# State Significant Development Application Report

## Hastings Secondary College - Port Macquarie Campus 16 Owen St, Port Macquarie NSW 2444

**Report Prepared for:** School Infrastructure NSW (SINSW)  
**Report Prepared by:** David Choe  
Philip Chun Accessibility Pty Ltd

**Our Ref:** AN021-216162  
**Date:** 21 April 2021

**HSPM                      SSDA-201083                      05**

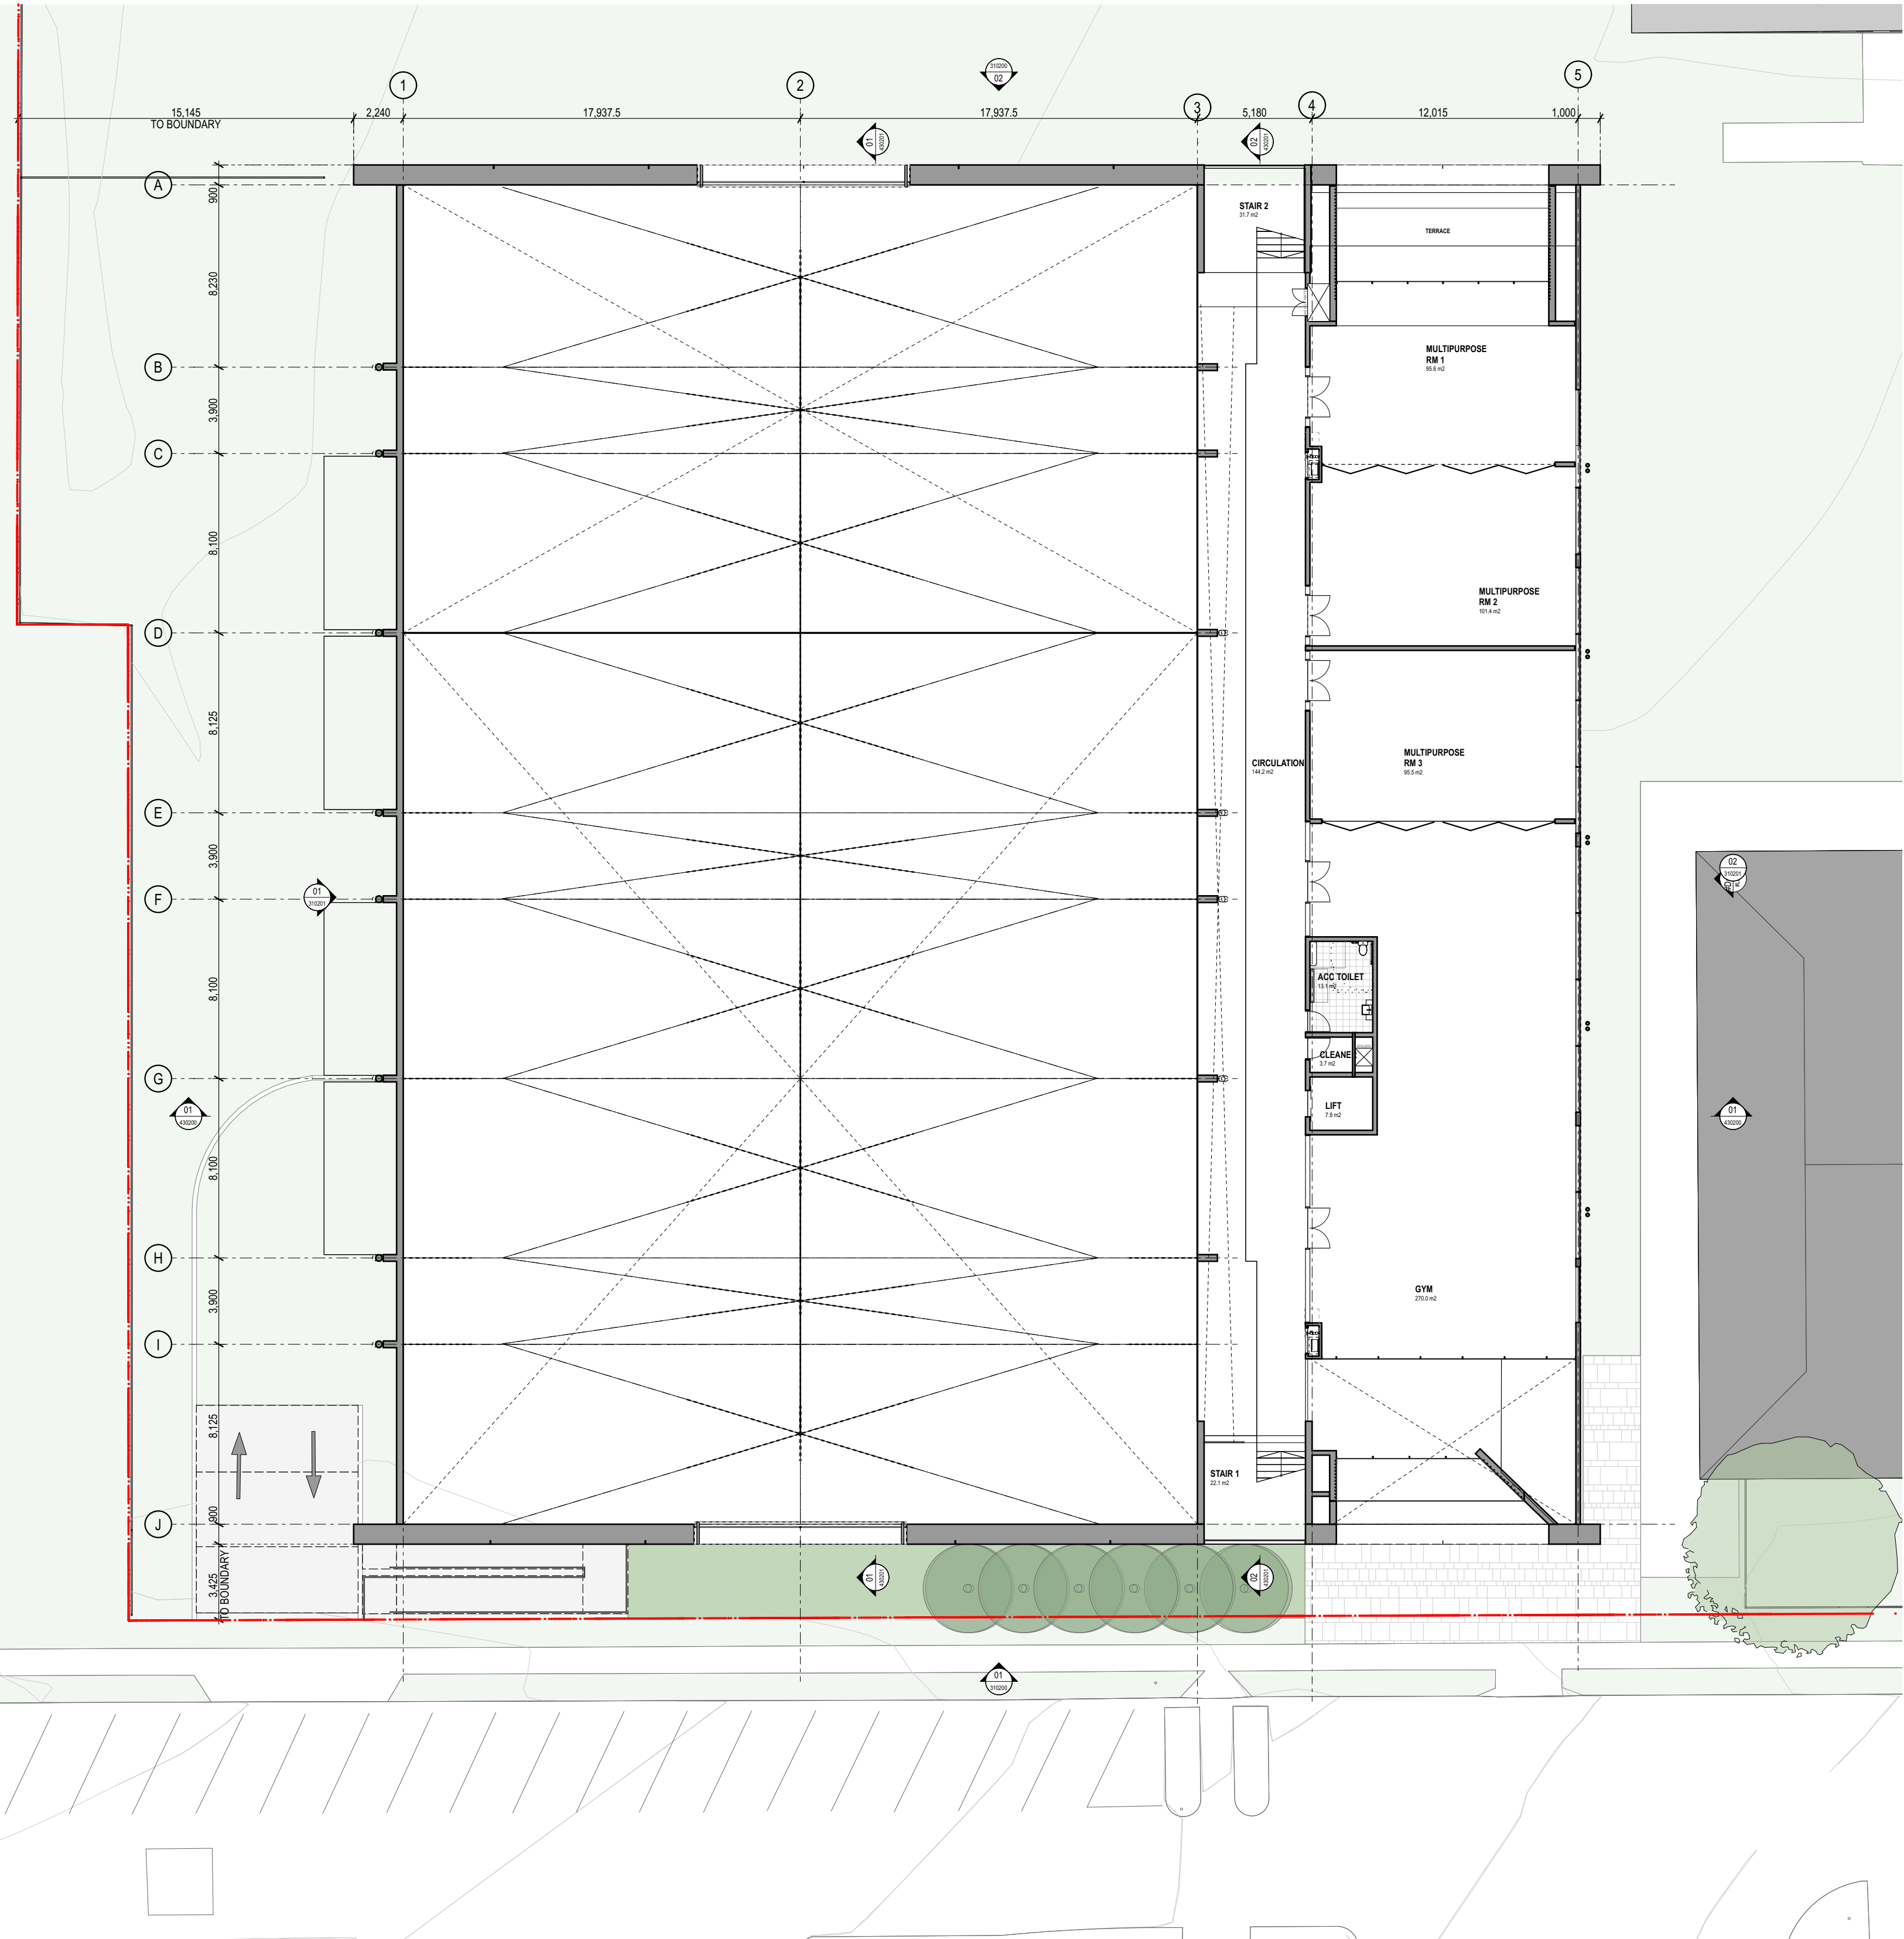
- c) During subsequent detailed design development stages, the scissor ramp associated with PCYC building can be further developed to prevent wheelchair users travelling outside the allotment boundary to access the PCYC building entrance on ground level from the lower ground level car park where there are accessible car parking spaces proposed.

2.	Access from the Accessible Carparking The BCA requires a continuous accessible path of travel be provided from the accessible carparking areas to the main entrance.	<b>Can Comply</b>	Complies in Principle.  Full compliance is subject to further design modifications and coordination during subsequent detailed design development stages.  During subsequent detailed design development stages, the scissor ramp can be further developed to prevent wheelchair users travelling outside the allotment boundary to access the PCYC building entrance on ground level from the lower ground level car park.

<b>D3.5 Accessible carparking</b>			
1.	The accessible carparking space and associated circulation spaces should comply with AS/NZS 2890.6.	<b>Can Comply</b>	<p>There appears to be a total of 21 x new car parking spaces proposed on the lower ground level of new PCYC building as shown on SSDA-201080 (rev. 03).</p> <p>Out of the 21 x car parking spaces proposed there are 2 x accessible car parking spaces proposed which readily satisfies minimum accessible car parking provision rate of BCA Clause D3.5.</p> <p>Full compliance is subject to detailed design coordination (e.g. adjacent shared zone and head clearances with service trays/sprinklers etc.) post SSDA-phase.</p>

Alternatively, recommend the passenger lift within PCYC building to travel down to the basement car park.
